NOTES ON CHANGES TO THE LAYOUT ORIGINALLY SUBMITTED FOR THE RESERVED MATTERS APPLICATION

CLIENT	STUART & MARCIA LYONS
PROJECT	WINDROOS, LITTLEHAMPTON
TITLE	PROPOSED SITE PLAN - RESPONSE TO RESERVED MATTERS COMMENTS

NUMBER	13121 - SK01 A
--------	----------------

NUMBER	13121 P.20.006-P2
--------	-------------------

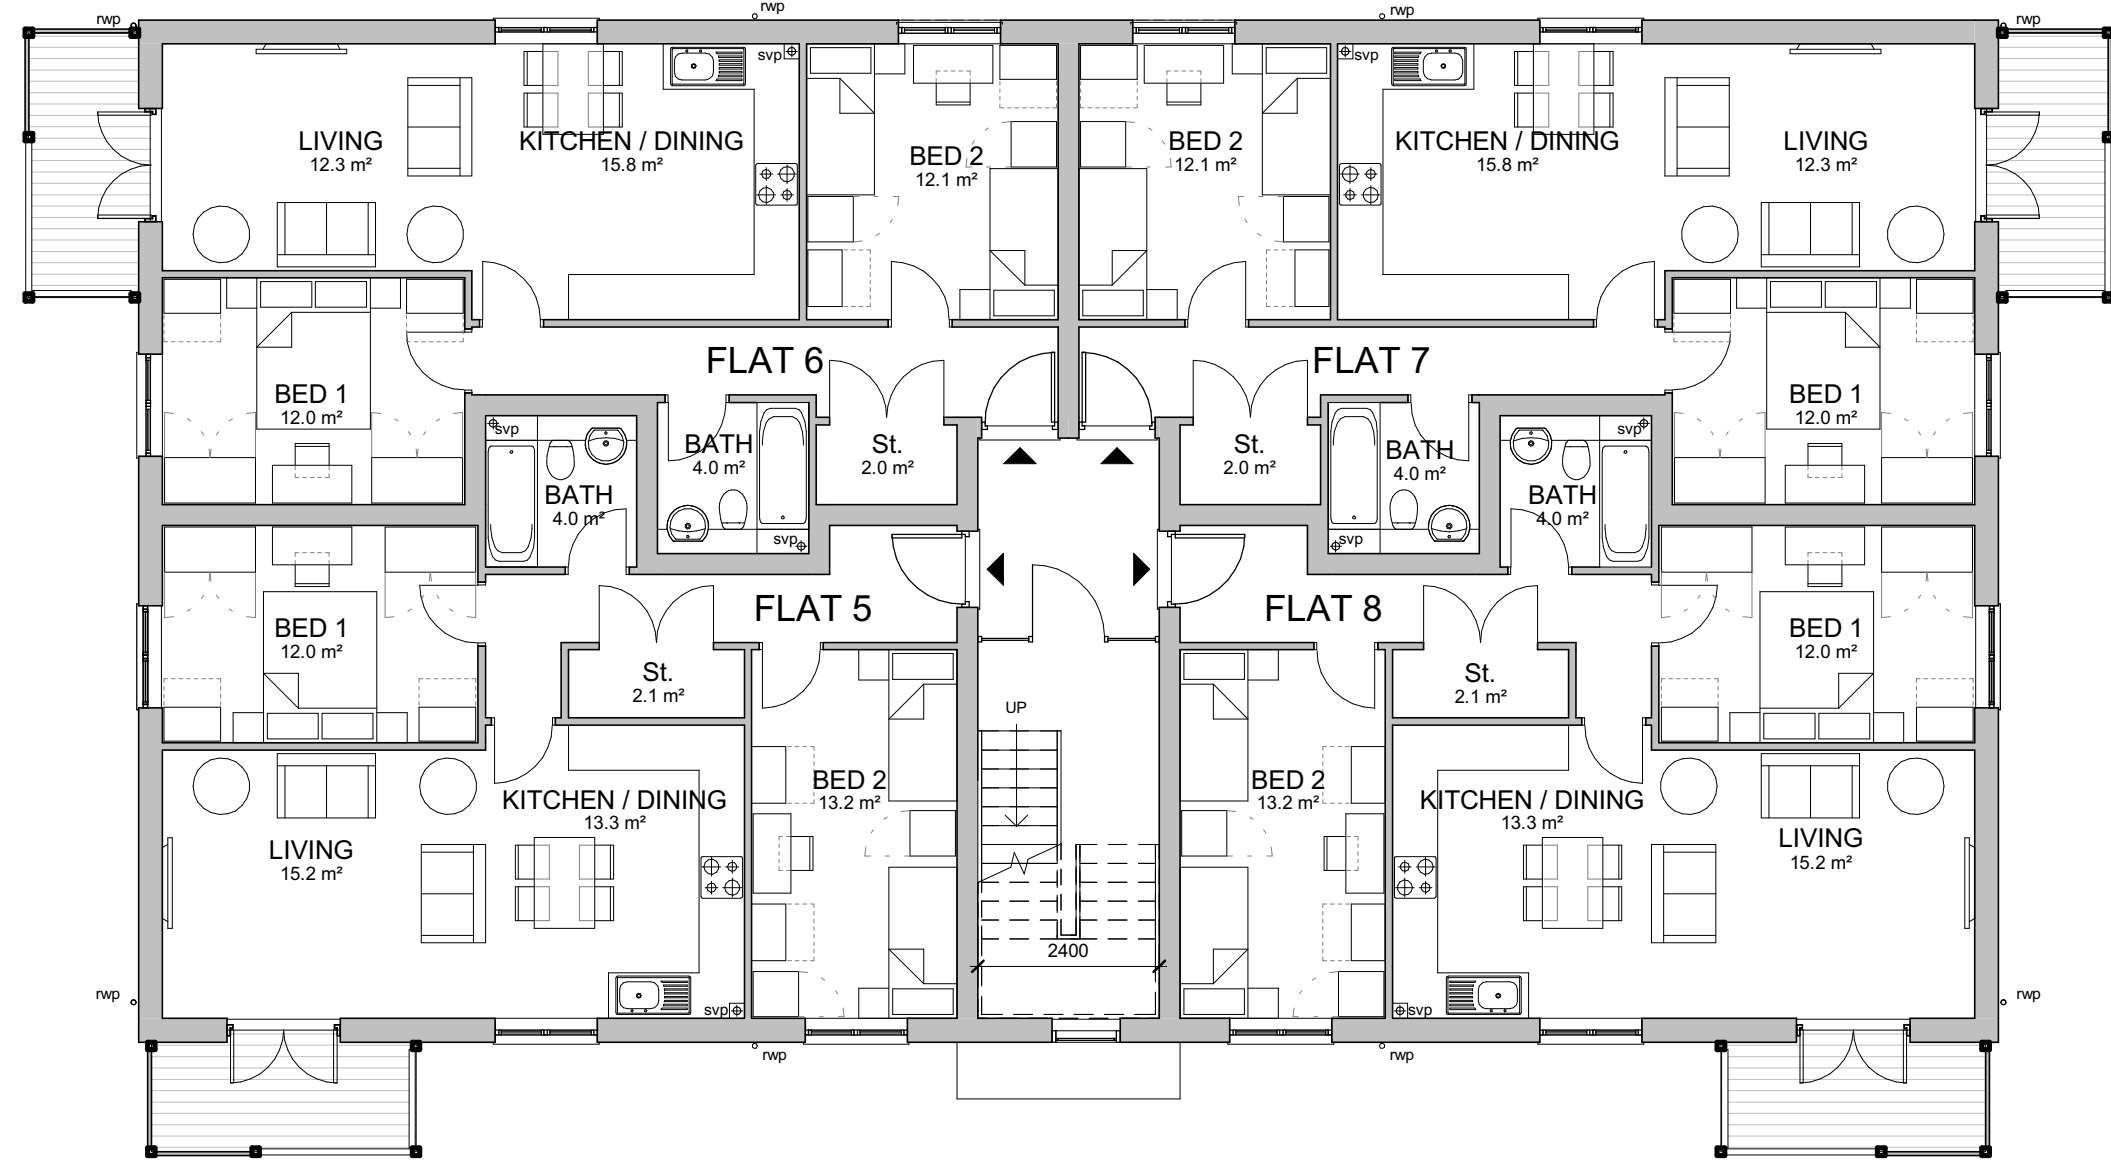
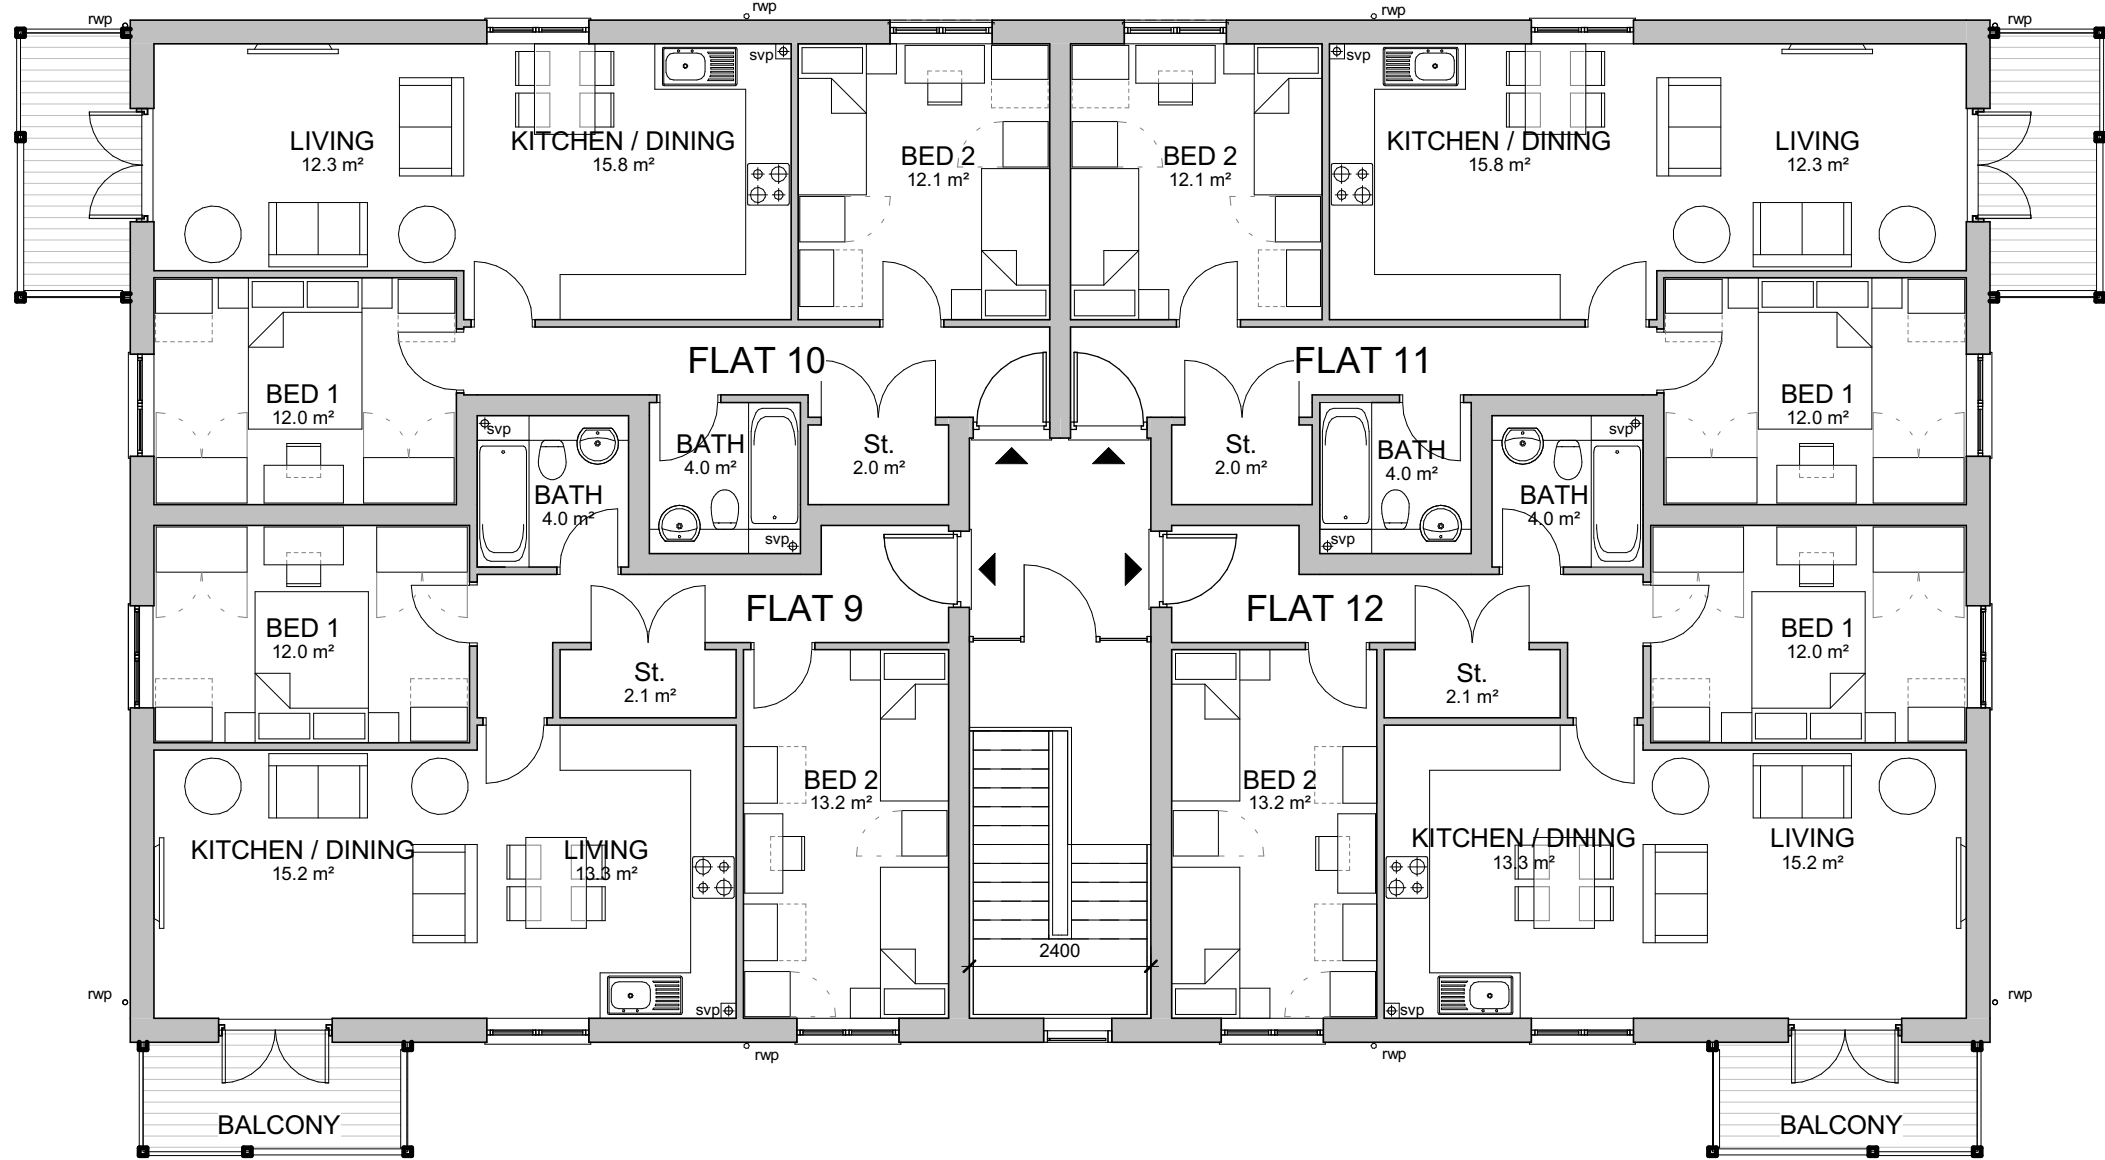
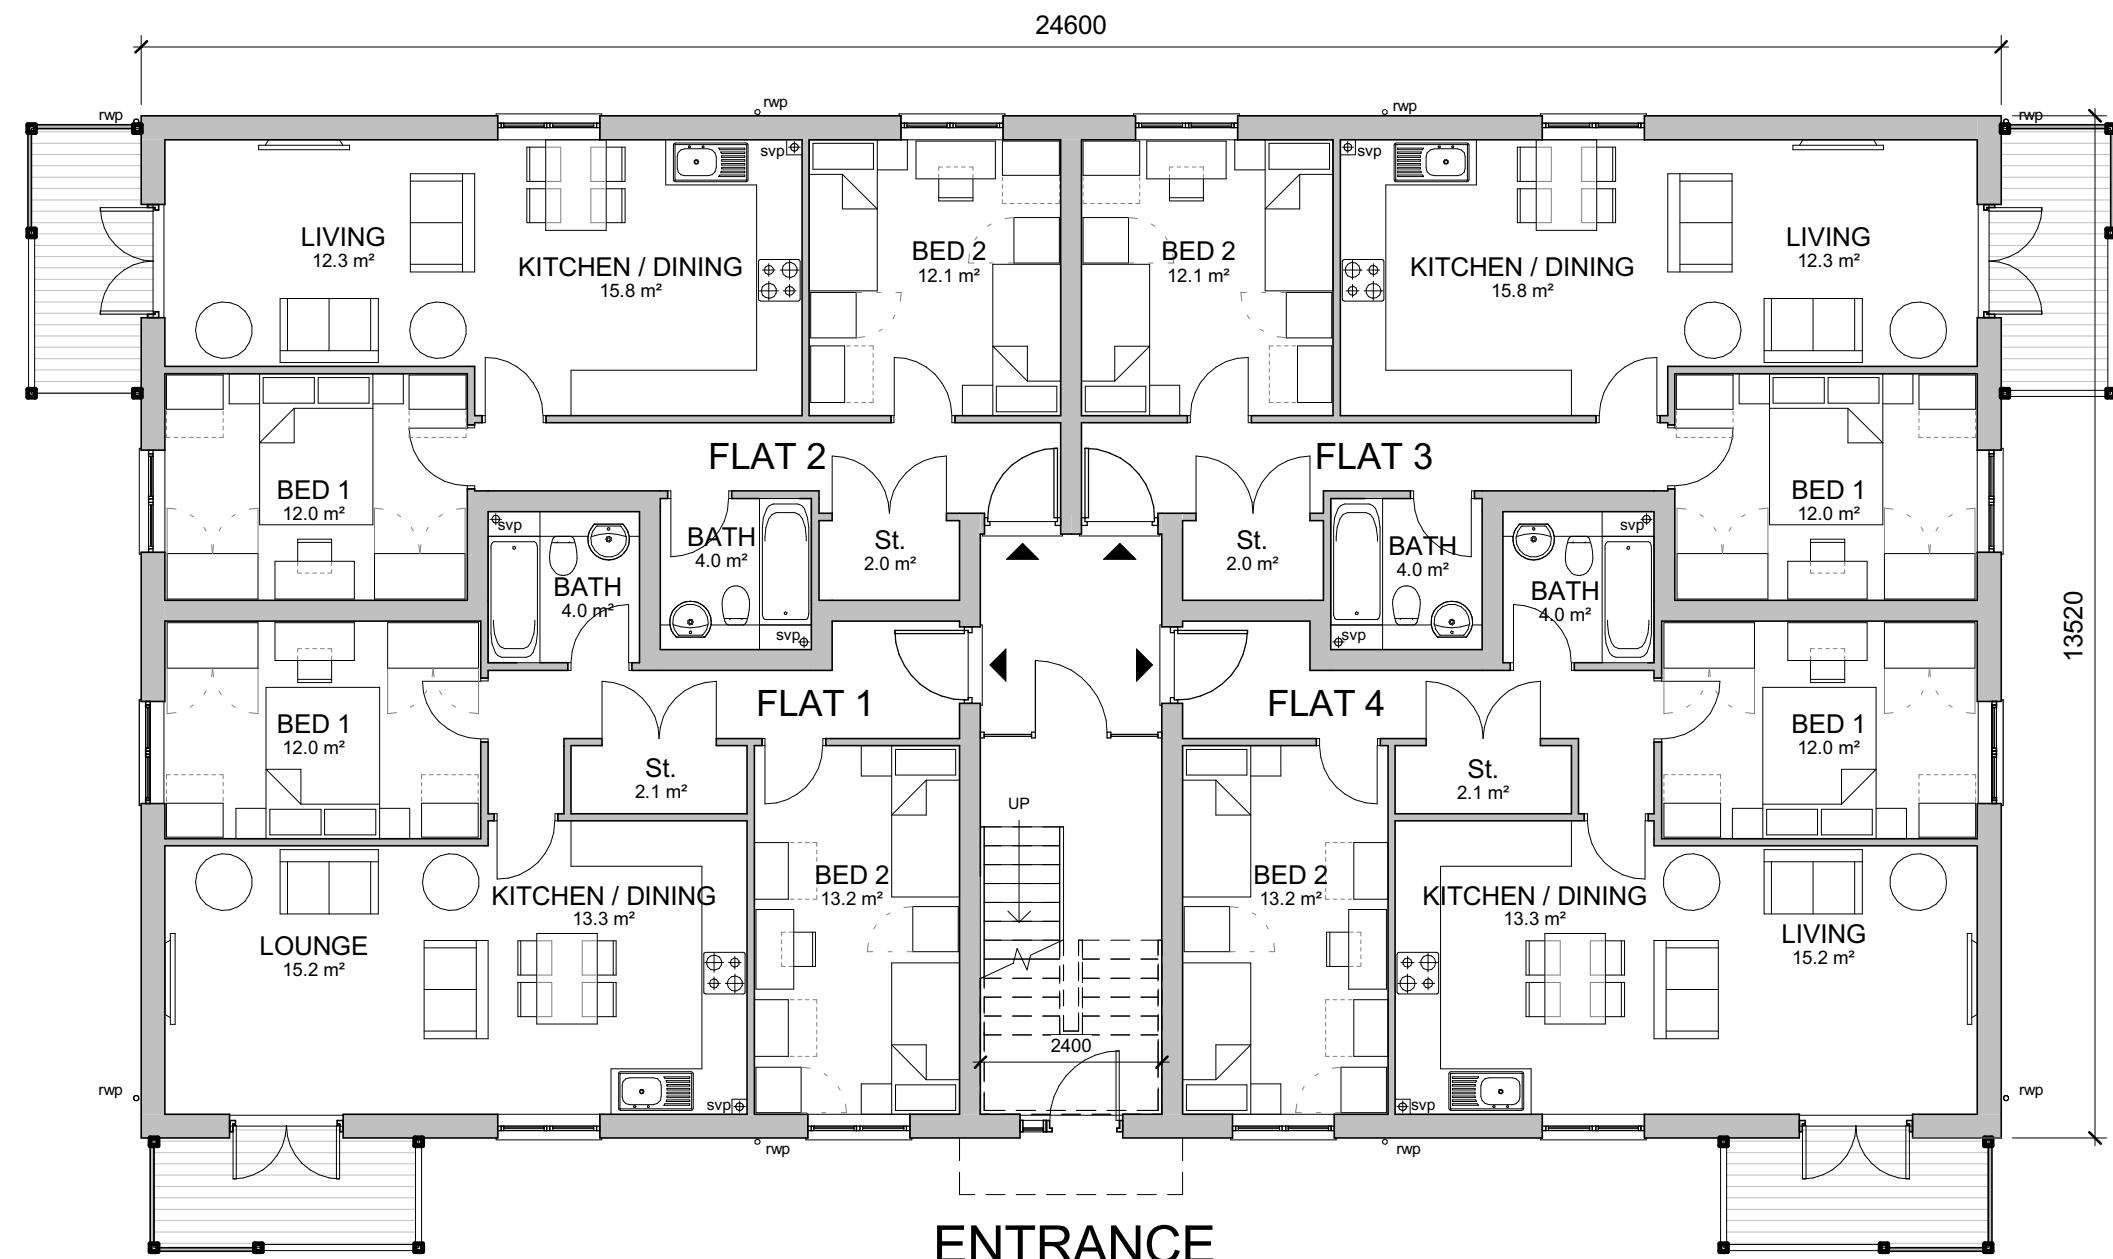
- Block of flats redesigned to provide more space between the building and site boundary.
- Flat visitor spaces moved to carriageway on south side of building formalising the parking in this location and to separate visitor and resident parking.
- Bin and cycle stores reconfigured to improve resident amenity and green space layout.
- 1 no. unallocated space omitted from submitted plan
